Department of Planning NSW

Proposed Carrington West Wing Open Pit Mine Extension
Hunter Valley Coal Measures

**Review of the Mackie
Environmental Research Modeling Report**

22 December 2010

APPENDIX 4  
CONCEPTUAL GROUNDWATER BARRIER WALL

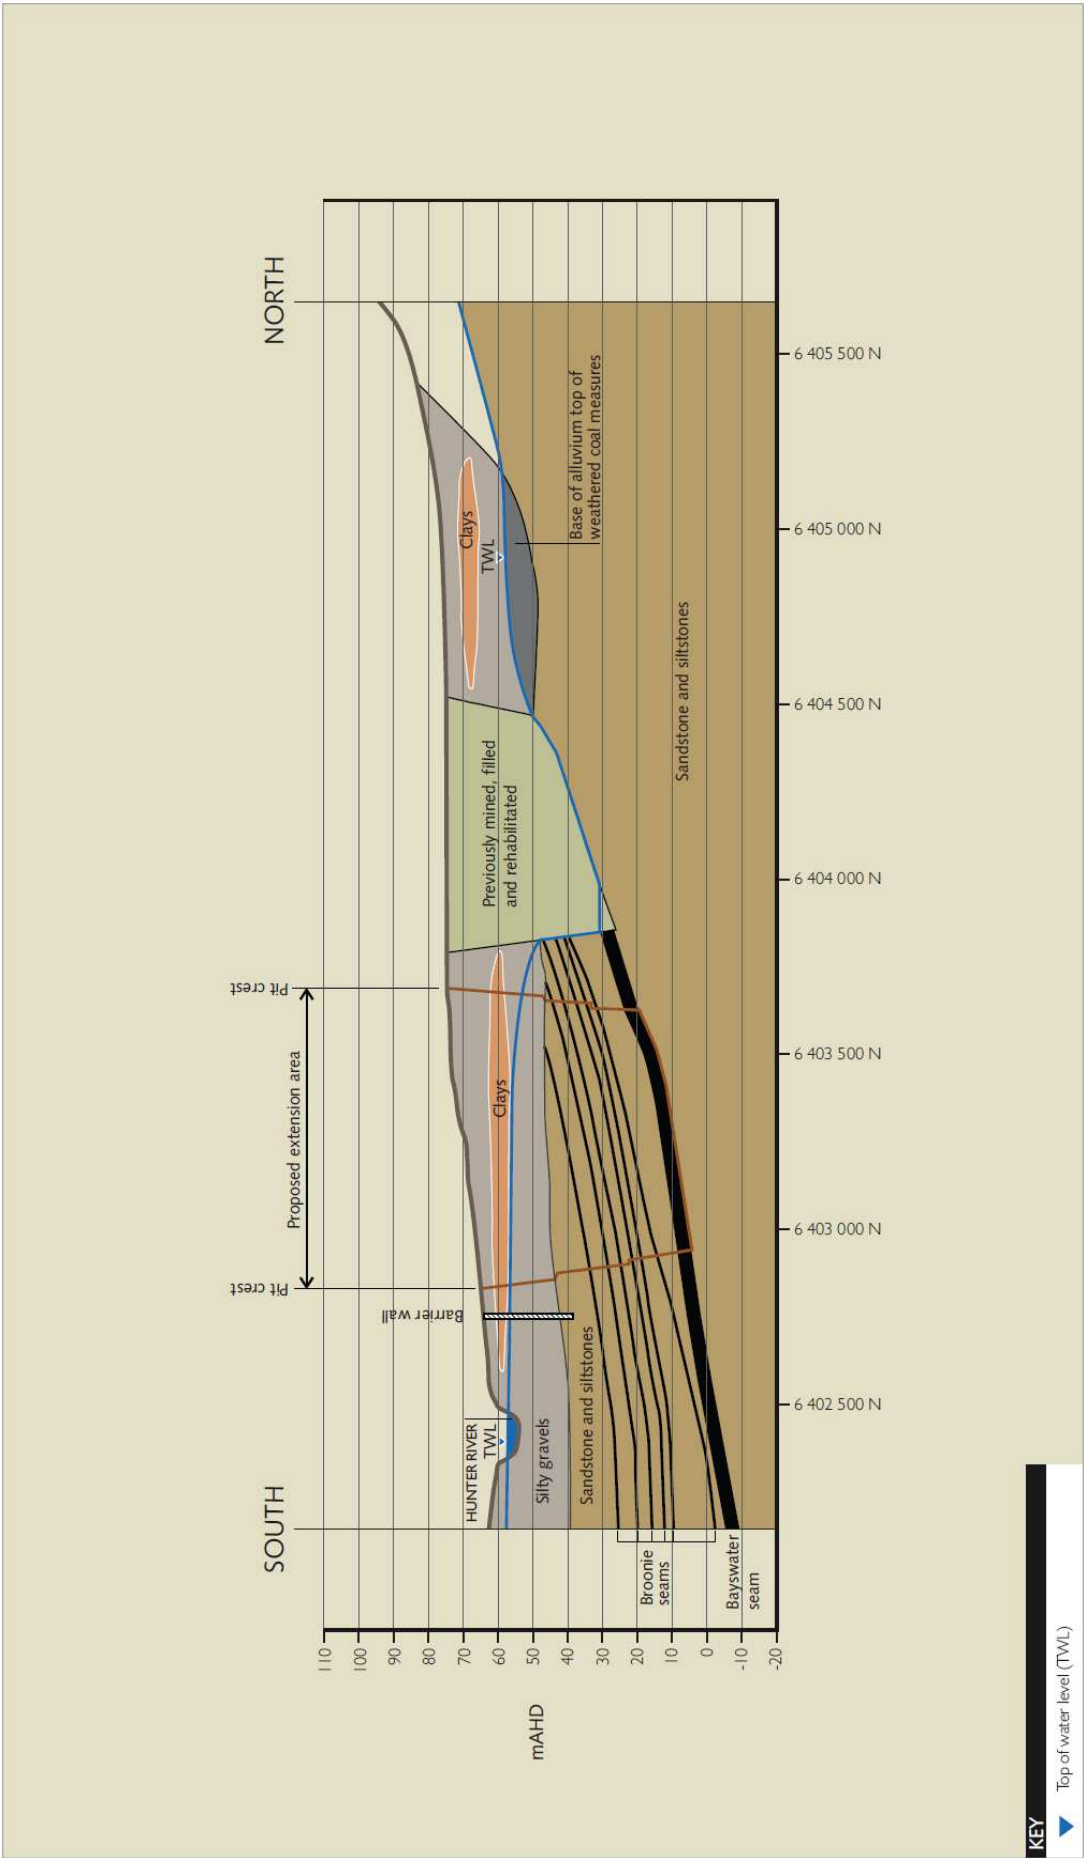
There is very little discussion or detail given in the Mackie report about these structures, with regard to their construction, materials to be used and validation of the permeability of the backfill material. It is understood from discussions I had with Dr Mackie that the barrier wall was designed and then constructed during 2010 across the eastern arm of the paleochannel under the supervision of consultants Parson-Brinckerhoff¹³. Because the details of construction and related matters are geotechnical in scope, they are therefore not reviewed herein because they lie outside my area of expertise. However, the issue of the permeability of the backfill material of this structure has a direct influence on sub-surface seepage flow and is therefore relevant with regard to this hydrogeological assessment and modeling review.

The Mackie report assumes a stripped insitu clay and bentonite (smectite clay) permeability of 10^{-6} m/day for modeling the barrier wall and proposed cutoff slurry-trench proposed across the western paleochannel arm. However, there is no evidence presented that validates the choice of such a permeability value. Bouwer (1978) indicates that a permeability value of 10^{-6} m/day is characteristic of deep clay beds, whilst Freeze (1979) puts such a value at the lower end of permeability for glacial till and un-weathered marine clay. There would be, in my opinion, uncertainty about whether such a uniform permeability could either be created or be maintained in a barrier wall of the type constructed in the long term. From my experience, a similar type of clay barrier constructed at another mine site to impede solute migration was designed to have a similar permeability as the Carrington barrier but after construction was found to have a reported permeability some orders of magnitude higher.

It would also be difficult to claim a permeability of less than 10^{-9} m/sec (i.e. $\sim 10^{-4}$ m/day) for bentonite or bentonite-cement slurry-trench. Hence the 1 to 2 metre wide deep slurry-trench that is proposed across the western paleochannel arm should be initially modeled (subject to geotechnical expert advice) with permeability in the range 10^{-3} to 10^{-4} m/day rather than 10^{-6} m/day to indicate the possible influence that would have on seepage rates towards the mining zone.

If not already done so, there needs to be a review conducted by a qualified geotechnical consultant with the necessary experience to comment on the integrity of the methods used for the construction of barrier clay wall and proposed slurry-trench and the long term integrity of these structures including determination and/or expert opinion about the initial and long term permeability of the materials used in their construction.

- No specific information or data is provided in the report about the existing clay barrier wall that extends across the eastern arm of the paleochannel or the proposed slurry cut-off trench proposed across the western arm of the paleochannel. In particular there is no evidence presented that validates the adopted permeability of 10^{-6} m/day that was used

for these barrier structures in the model. Initially, and without further evidence or expert geotechnical opinion, permeability values in the range 10^{-3} and 10^{-4} m/day should be adopted in the model for these barrier structures.

- There needs to be a review conducted by a qualified geotechnical consultant with the necessary experience to comment on the integrity of the methods used for the construction of barrier clay wall and proposed slurry-trench and the long term integrity of these structures including determination and/or expert opinion about the initial and long term permeability of the materials used in their construction.
